Submission to Application SSI-9737 Sydney Gateway road project.

I object to the NSW Department of Planning's approving the Sydney Gateway Road Project on a number of grounds –

Table 4-1 Representative sensitive receptor locations

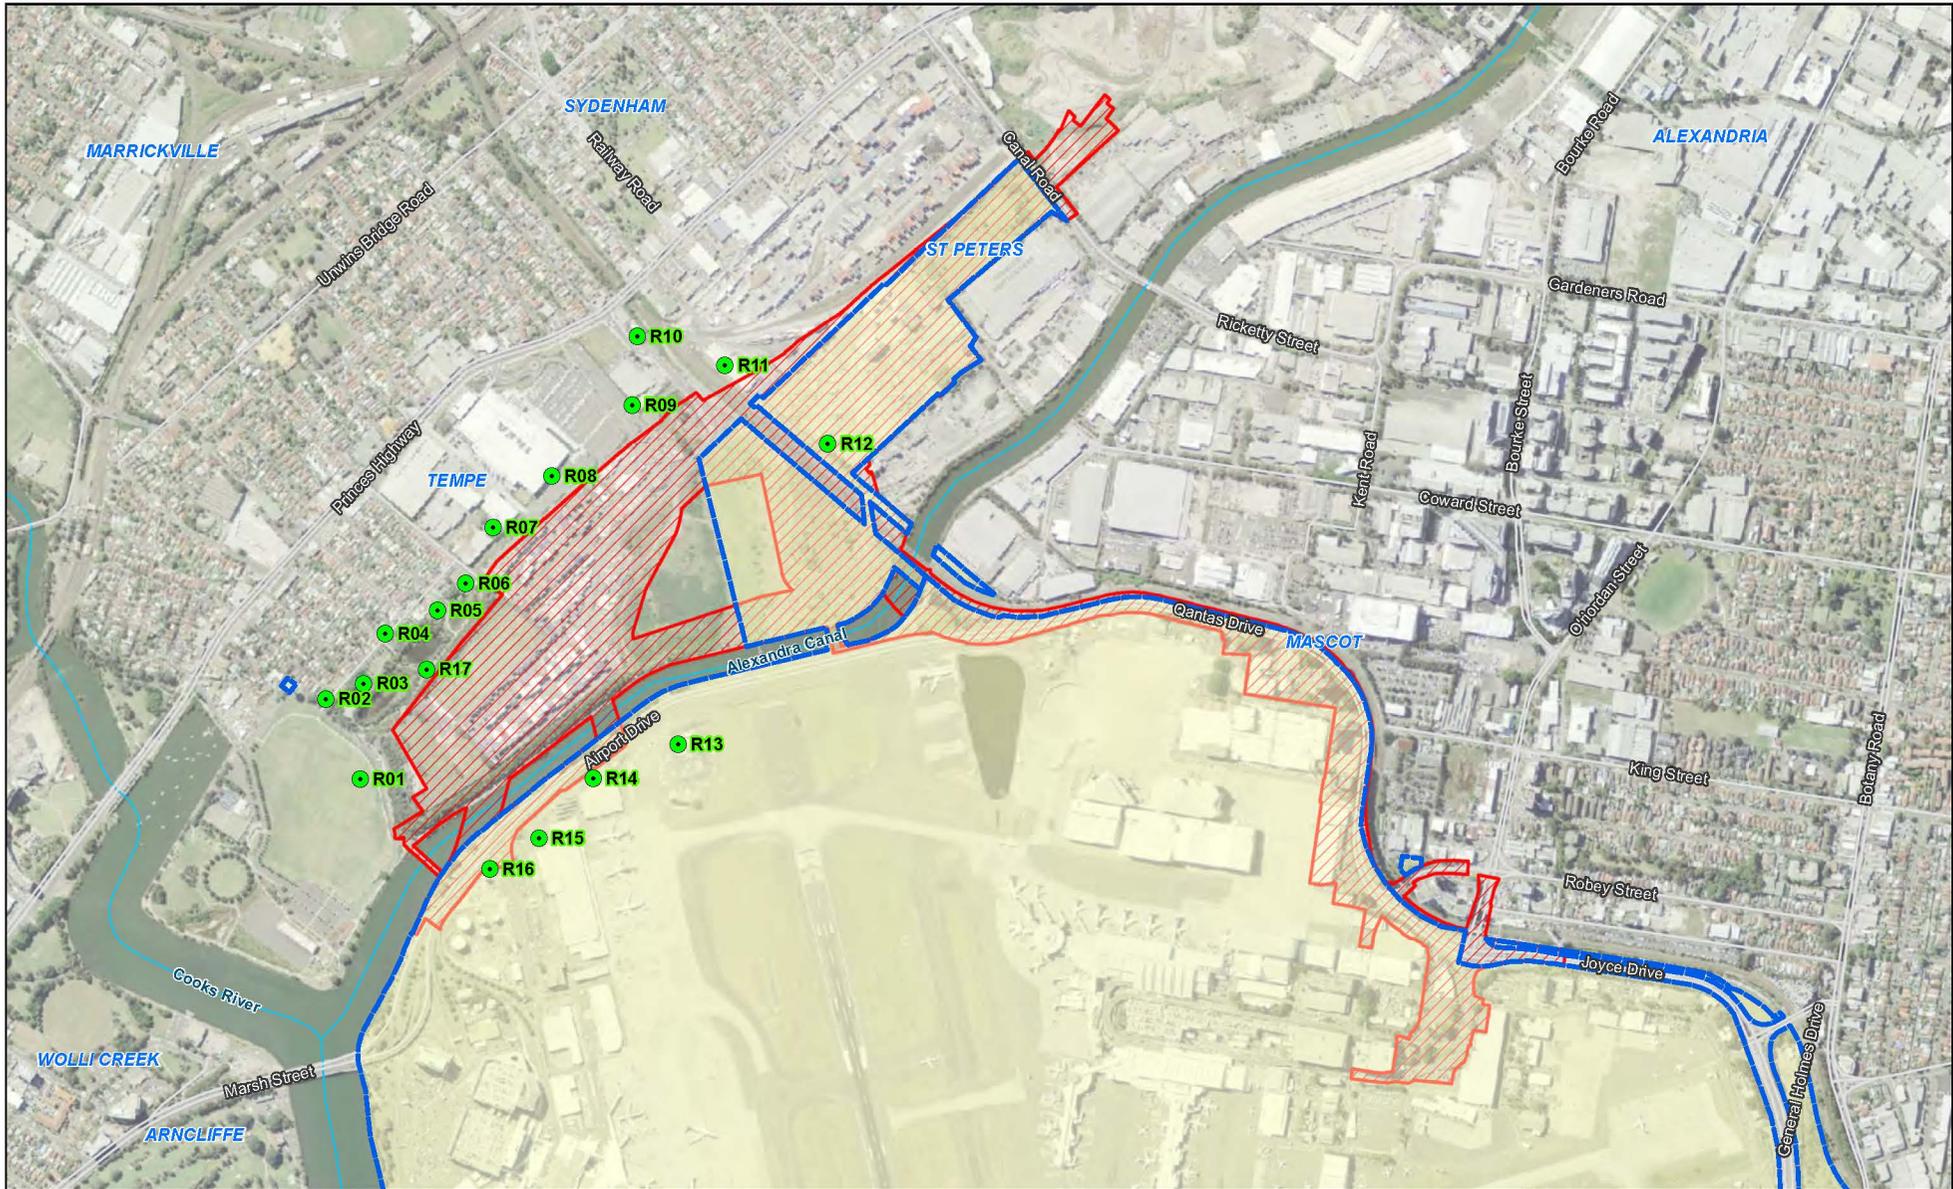
The “Representative sensitive receptor locations” (Table 4-1, p. 26) do not include the Tempe High School nor the St Peters School and childcare centre. While these two sites are on the edge of the Tempe landfill ‘s surrounds, the 2017 experience was that the prevailing on-coast winds pushed the stink from the SPI across Sydney Park, up to Sydney Park Rd, to the end of King St near St Peters Station and across the Princes Highway and Unwins Bridge Rd. It made life for residents a misery for months and kept the community’s children out of the parks and play grounds and away from school on the worse days.

Figure 5-1  
Predicted Odour Concentration during Scenario 1 (OU, 99th Percentile)

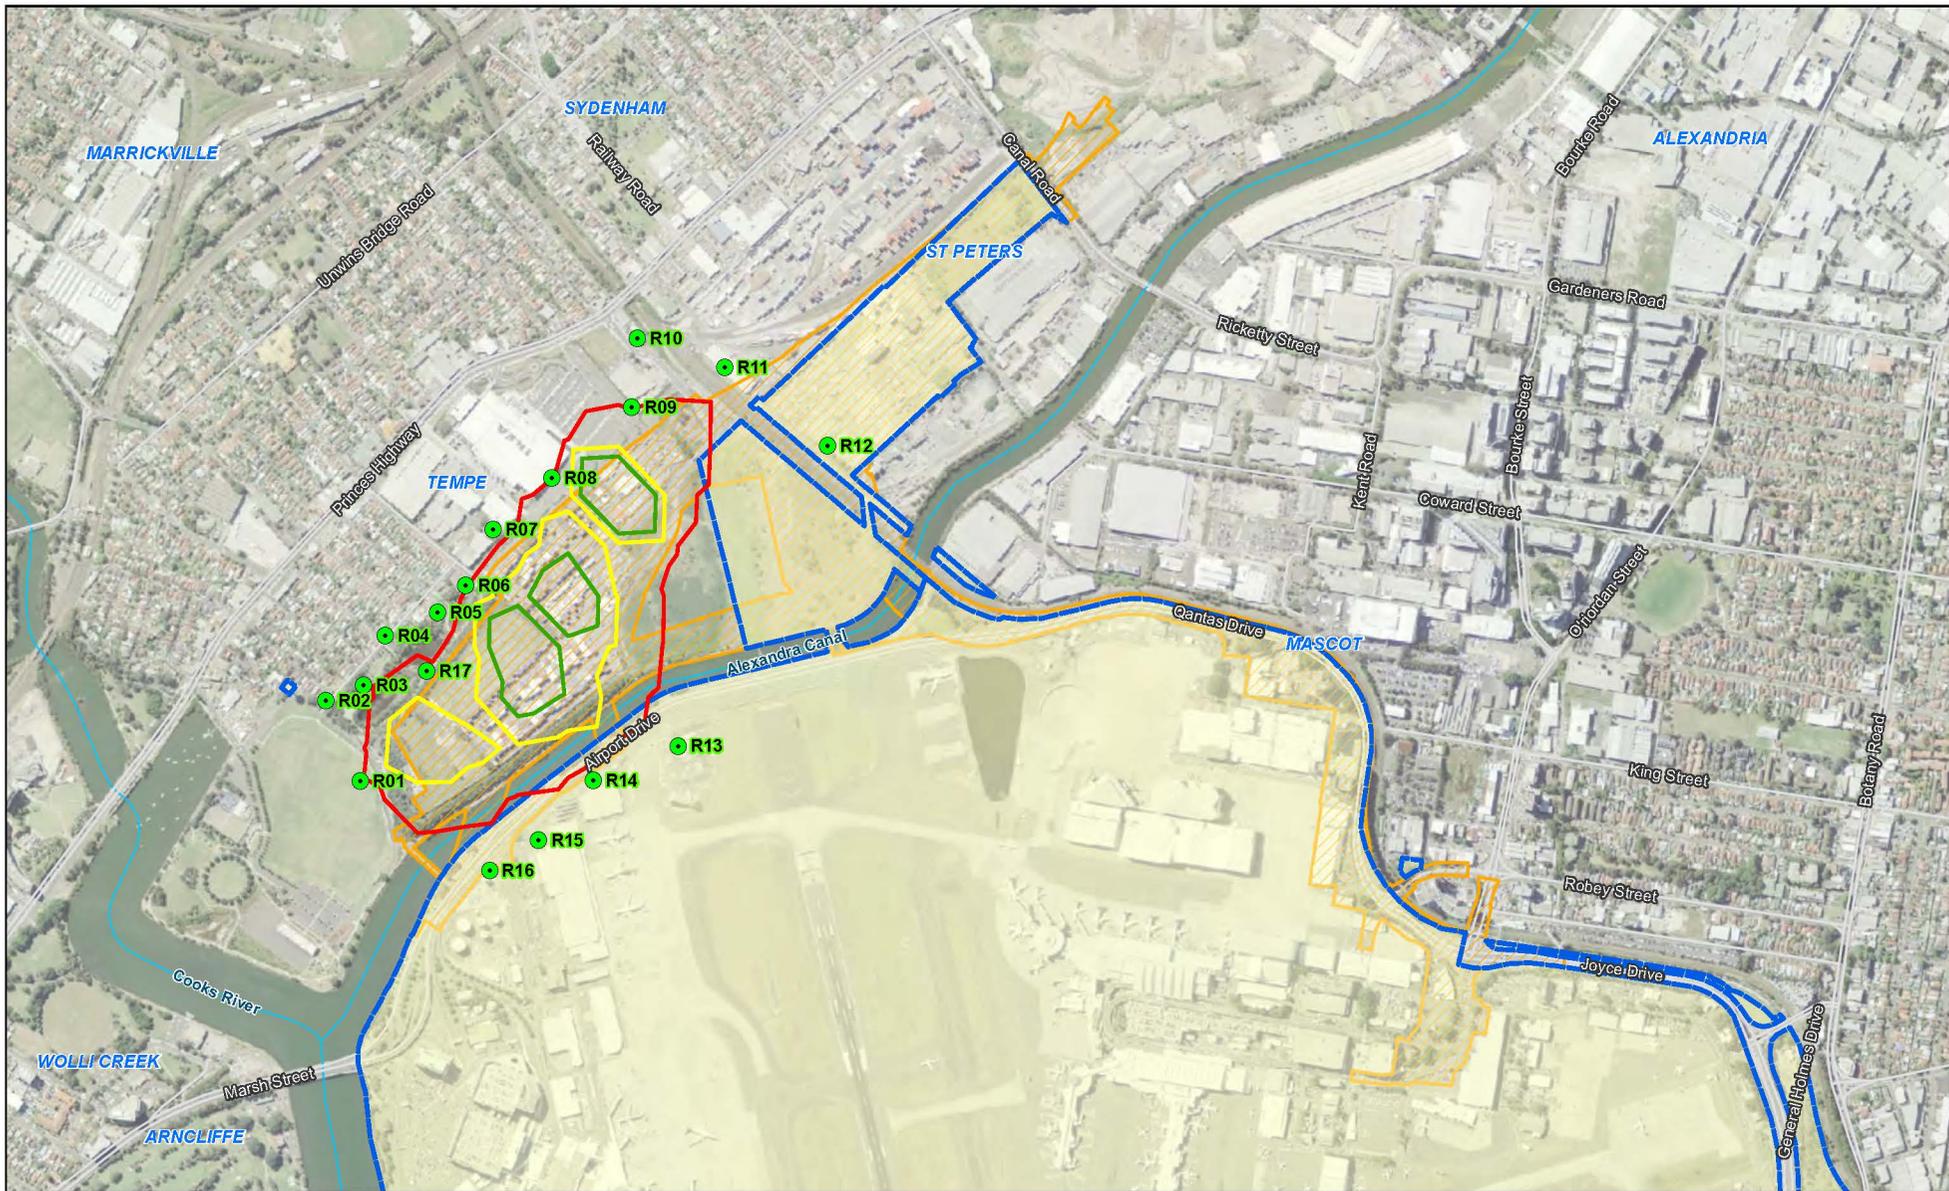
It is impossible to tell from the technical description in the TWP 17, eg the “2 OU assessment criterion”, whether the allowable volume of offensive odours are reasonable or not. If it is detectable, particularly from some distance from the site then it is exceeding a reasonable level.
